Historic Preservation Certification Application
State Historic Preservation Office Review & Recommendation Sheet
Significance - Part 1

Number 1	George S. Hunt Block (Property) 660 Congress Street, Portland, ME
Congress Street Historic District and Spring Street Historic District (Historic District)

CONDITIONS SHEET
Historic Preservation Certification Application

PROPERTY: George S. Hunt Block, 660-662 Congress Street, Portland, ME
PROJECT NUMBER: 28761
APPLICATION: Part 2 Amendment
DECISION: Approval

**2** WEST STOREFRONT ELEVATIONS (WINDOW 3)  
A-603 1/2" = 1'-0"

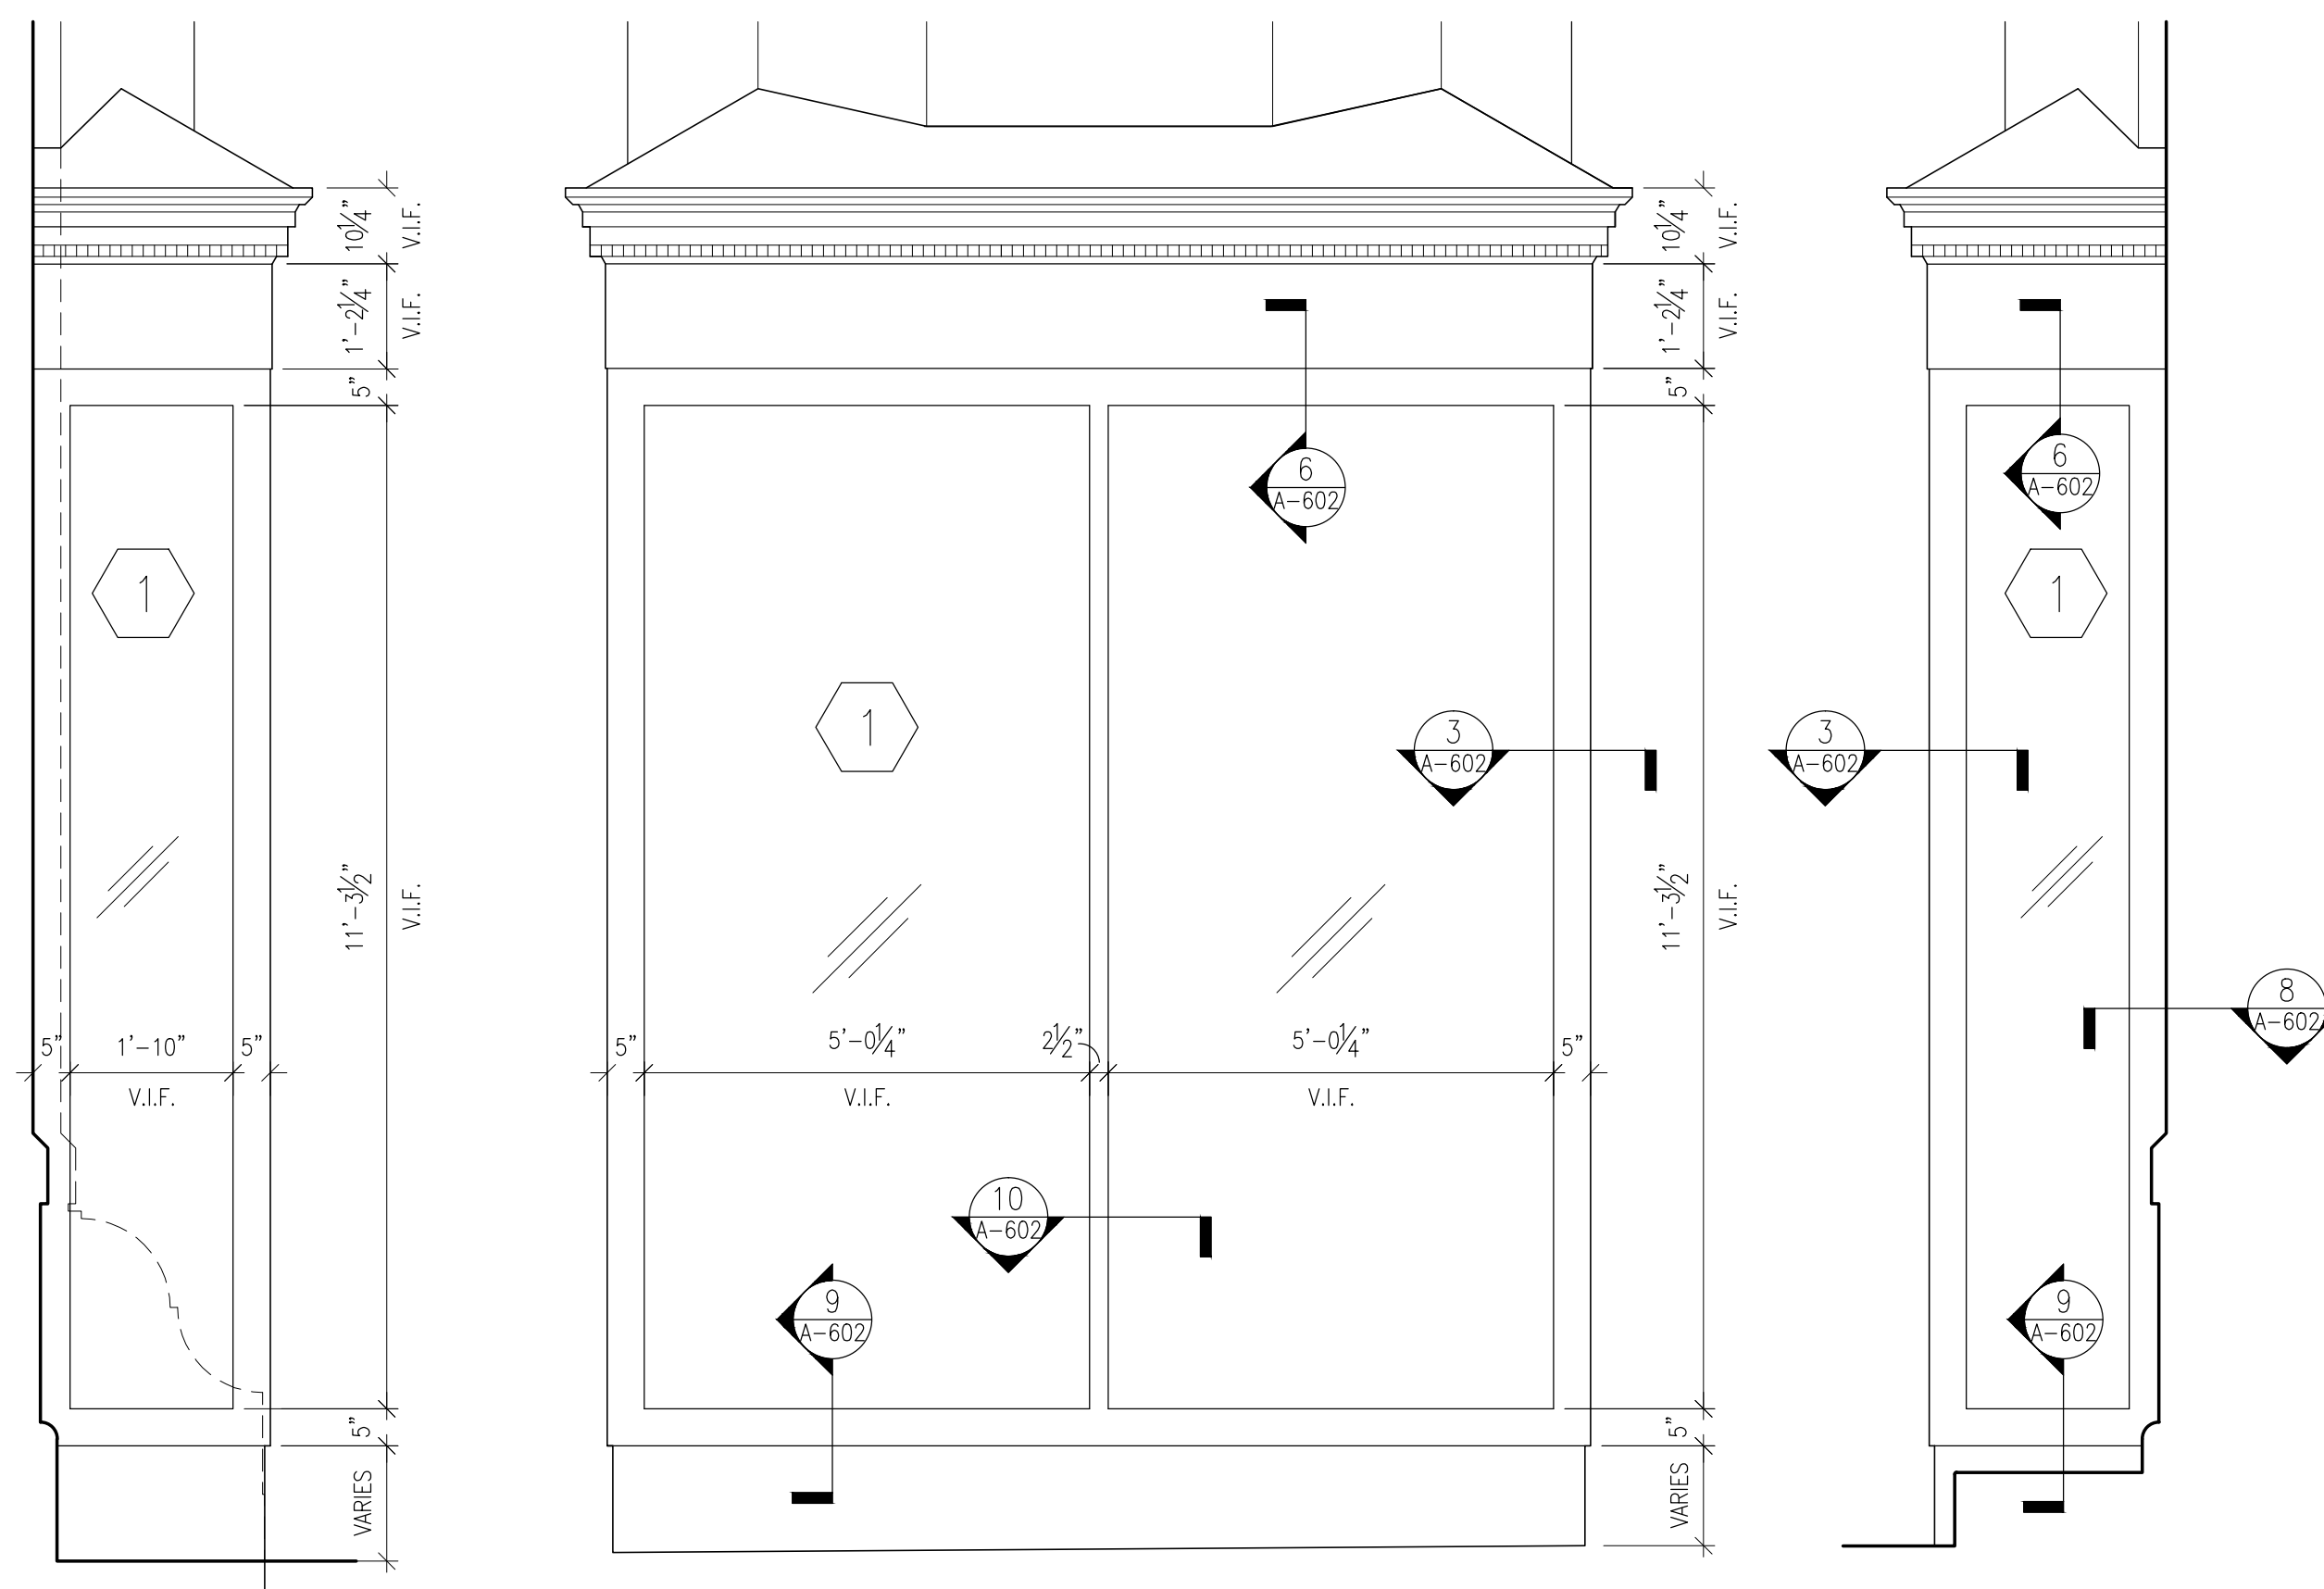
Storefront Windows – The replacement first floor commercial bay window located on the eastern side of the Congress Street elevation must match the configuration of the existing multi-light window designed by John Howard Stevens. This 1950 window was constructed during the period of significance for the Congress Street Historic District and has gained significance in its own right. The proposed window is not based on any historical documentation and is not compatible with the proportions of the façade.

The National Park Service has reviewed the additional information received on August 27, 2013 for the above-referenced Historic Preservation Certification Application for this project. After careful consideration, we have determined that the revised storefront proposal is in conformance with the Secretary of the Interior's Standards for Rehabilitation and with the preliminary approval issued by this office on May 29, 2013.
